Date: 30 September 2019
Our ref: 295000
Your ref: M45 J6 ancient woodland TN8.64 / TR010027

**M42 Junction 6 Development Consent Order Scheme Number TR010027
Technical Note 8.64 Ancient Woodland Clarifications and Proposed Additional Measures
Natural England response**

Drawing Title  
**FIGURE 8.3 PROPOSED LANDSCAPE PLANTING SHEET 1 OF 3**

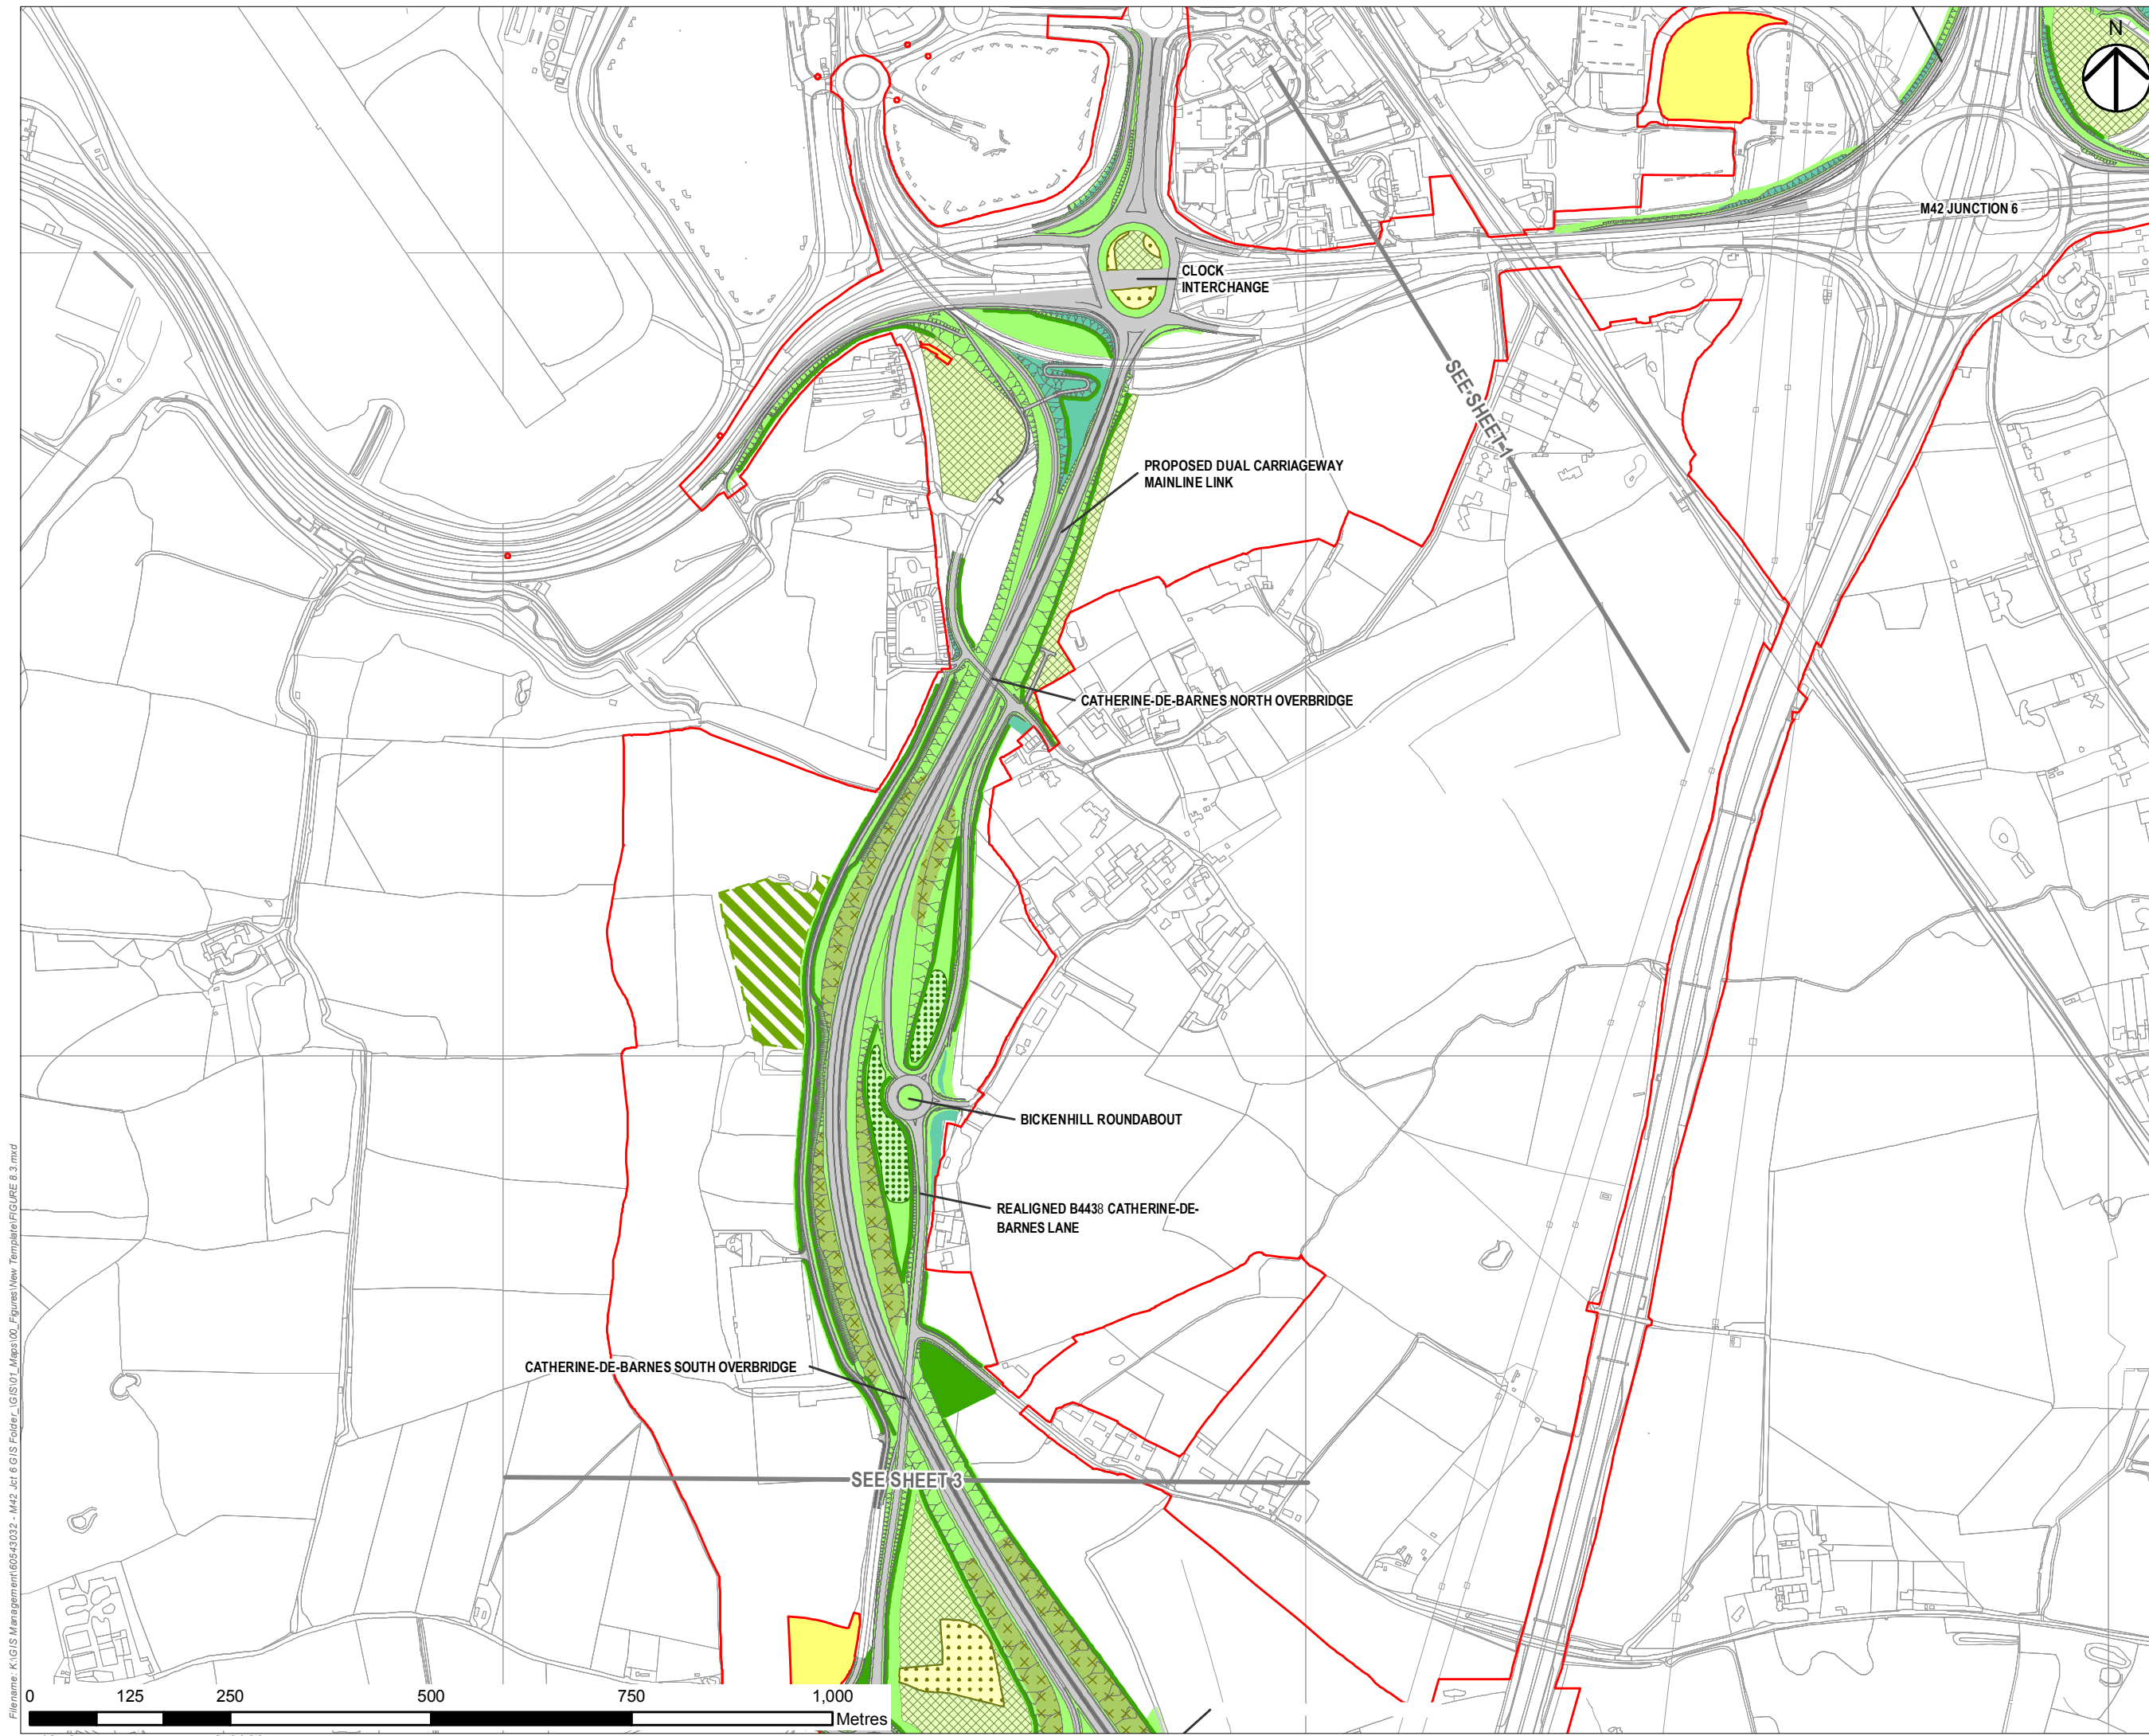
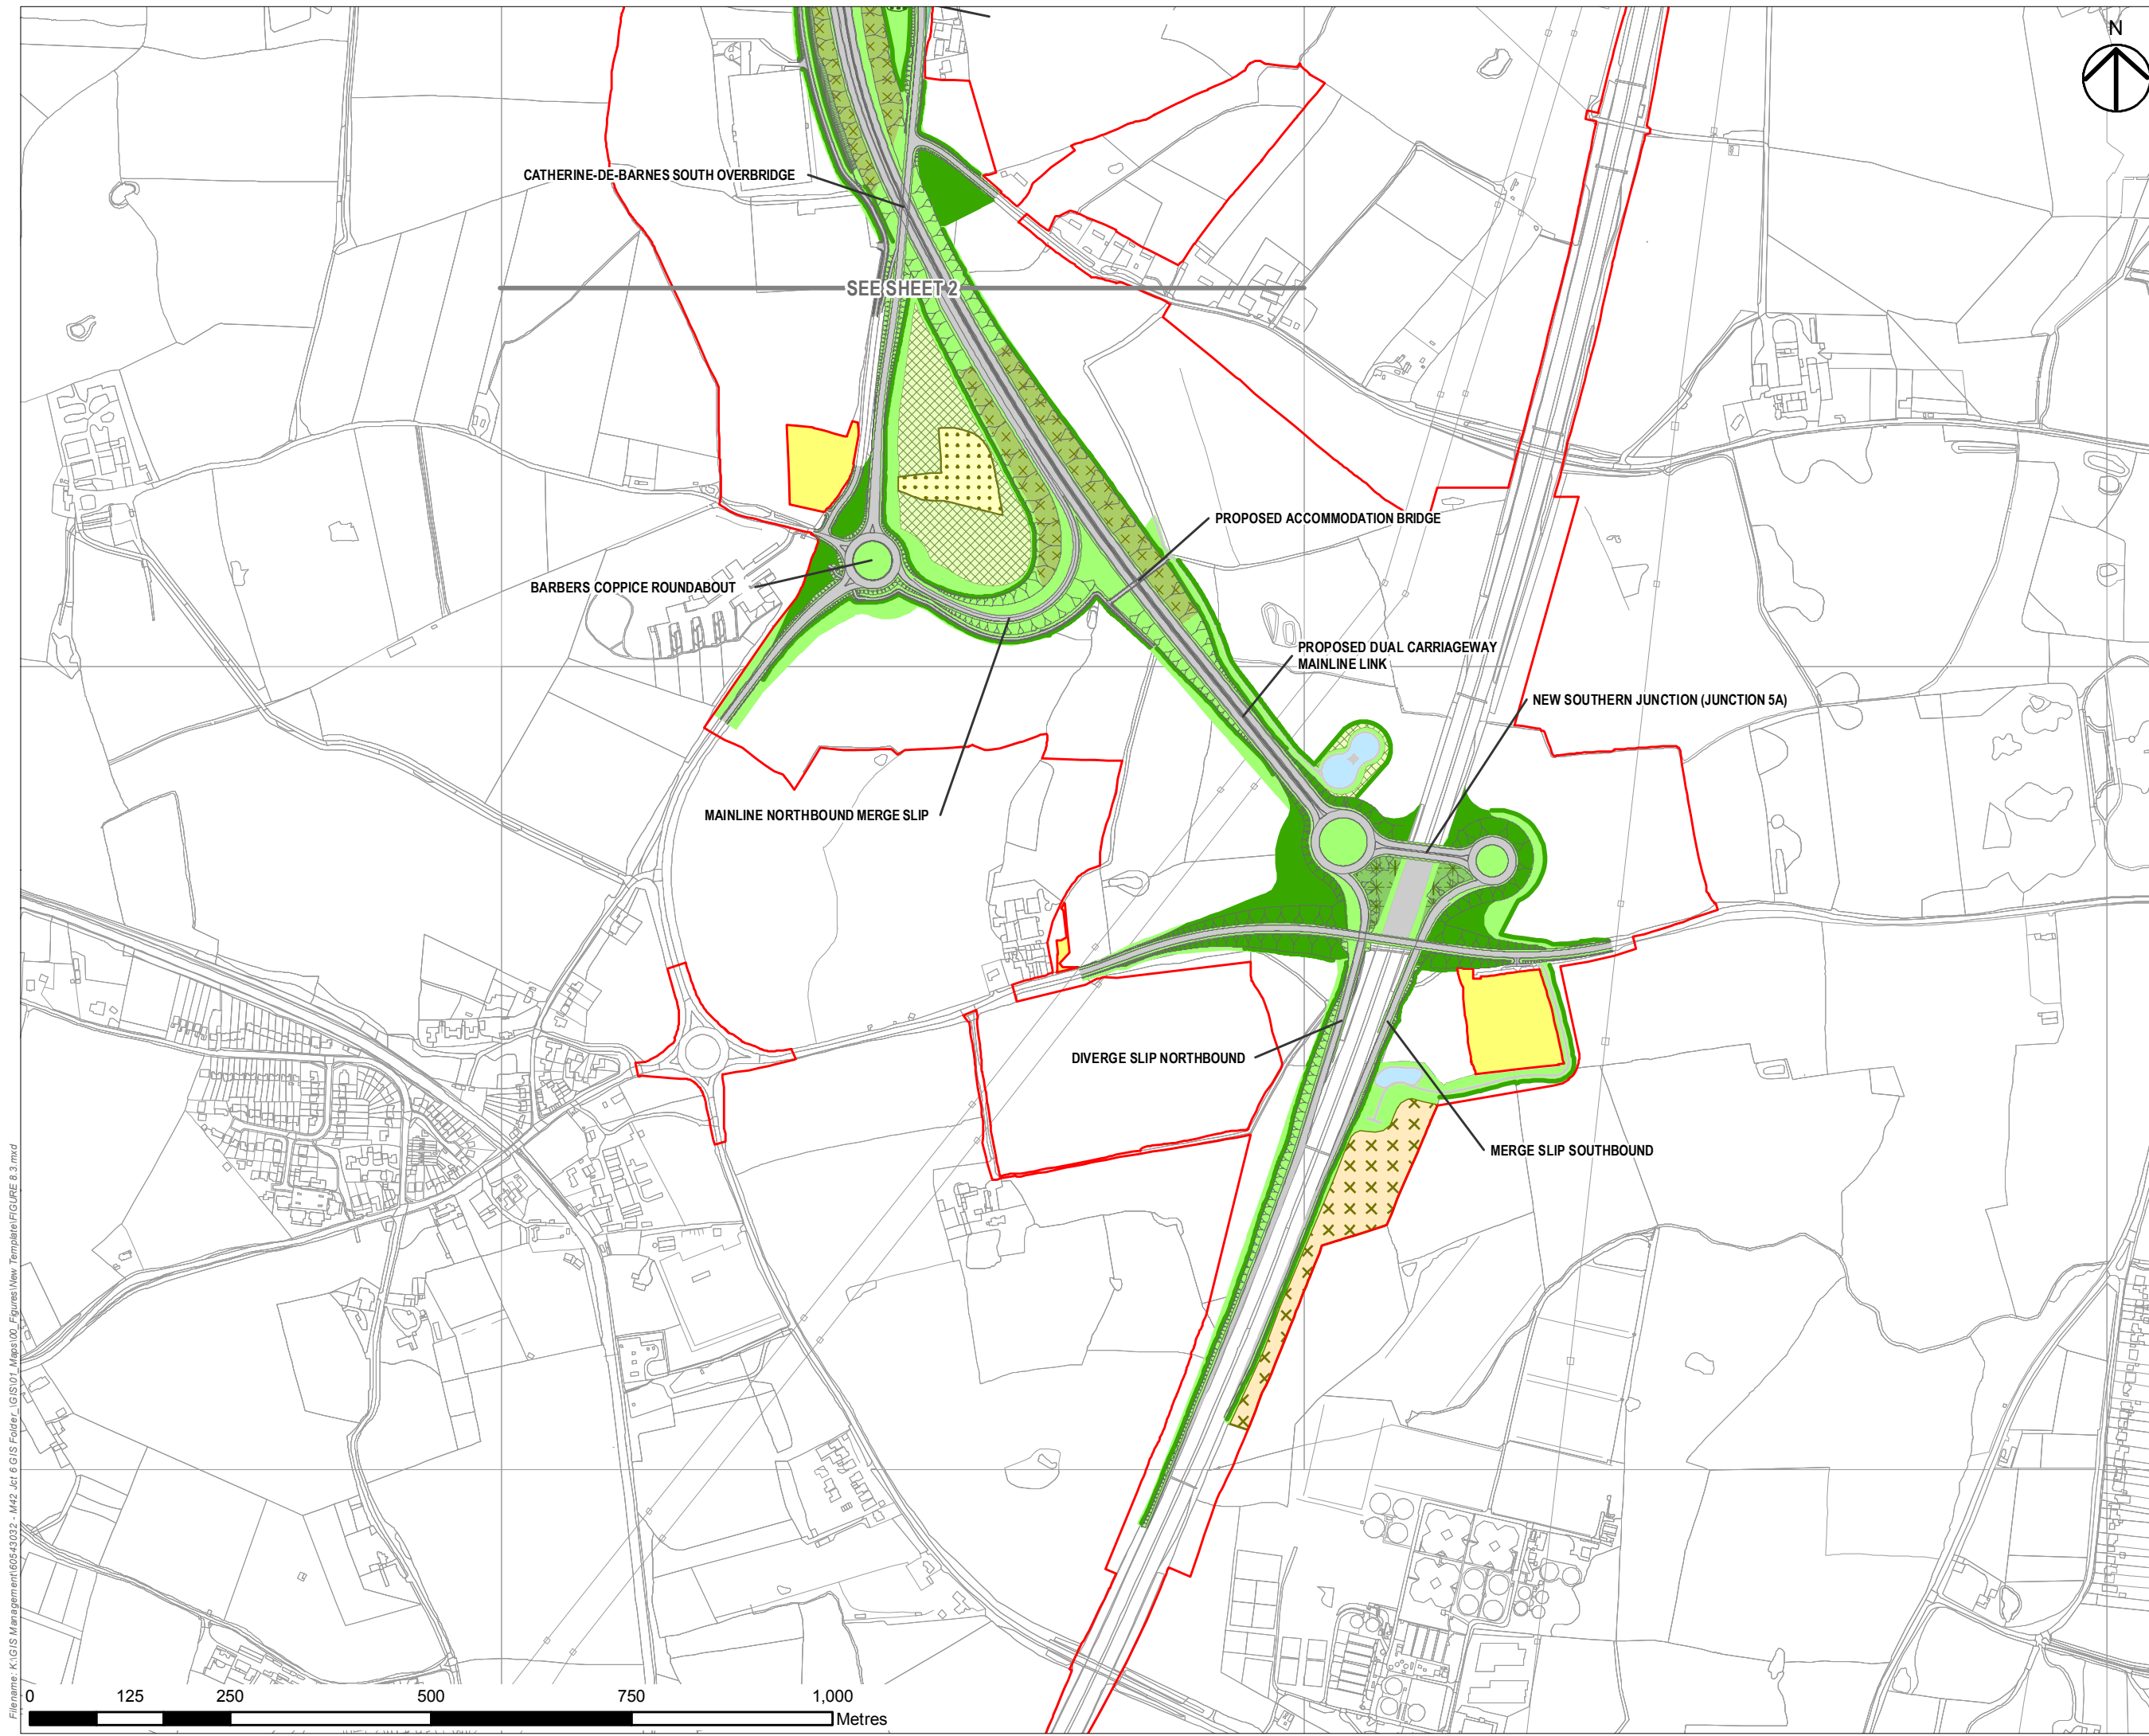
Natural England stresses the importance of securing suitable management of Aspbury's Copse and recommends that suitable management of Barber's Copse is also secured as part of the compensatory package. Natural England will be pleased to comment on draft management plans.

Finally, Natural England welcomes the pursuit of further compensatory woodland habitat and wishes to emphasise that adding land on the western side of the M42, preferably contiguous with Aspbury's Copse should be sought as the highest priority. Any opportunities for buffering of Aspbury's Copse, with potential to mitigate impacts, should also be prioritised. We would also reiterate the need for compensatory habitat to have functional connections with the habitat network. We note the commitment to providing a minimum of compensatory woodland habitat of 7:1, but urge that all avenues are explored vigorously and fully to maximise compensatory woodland habitat.
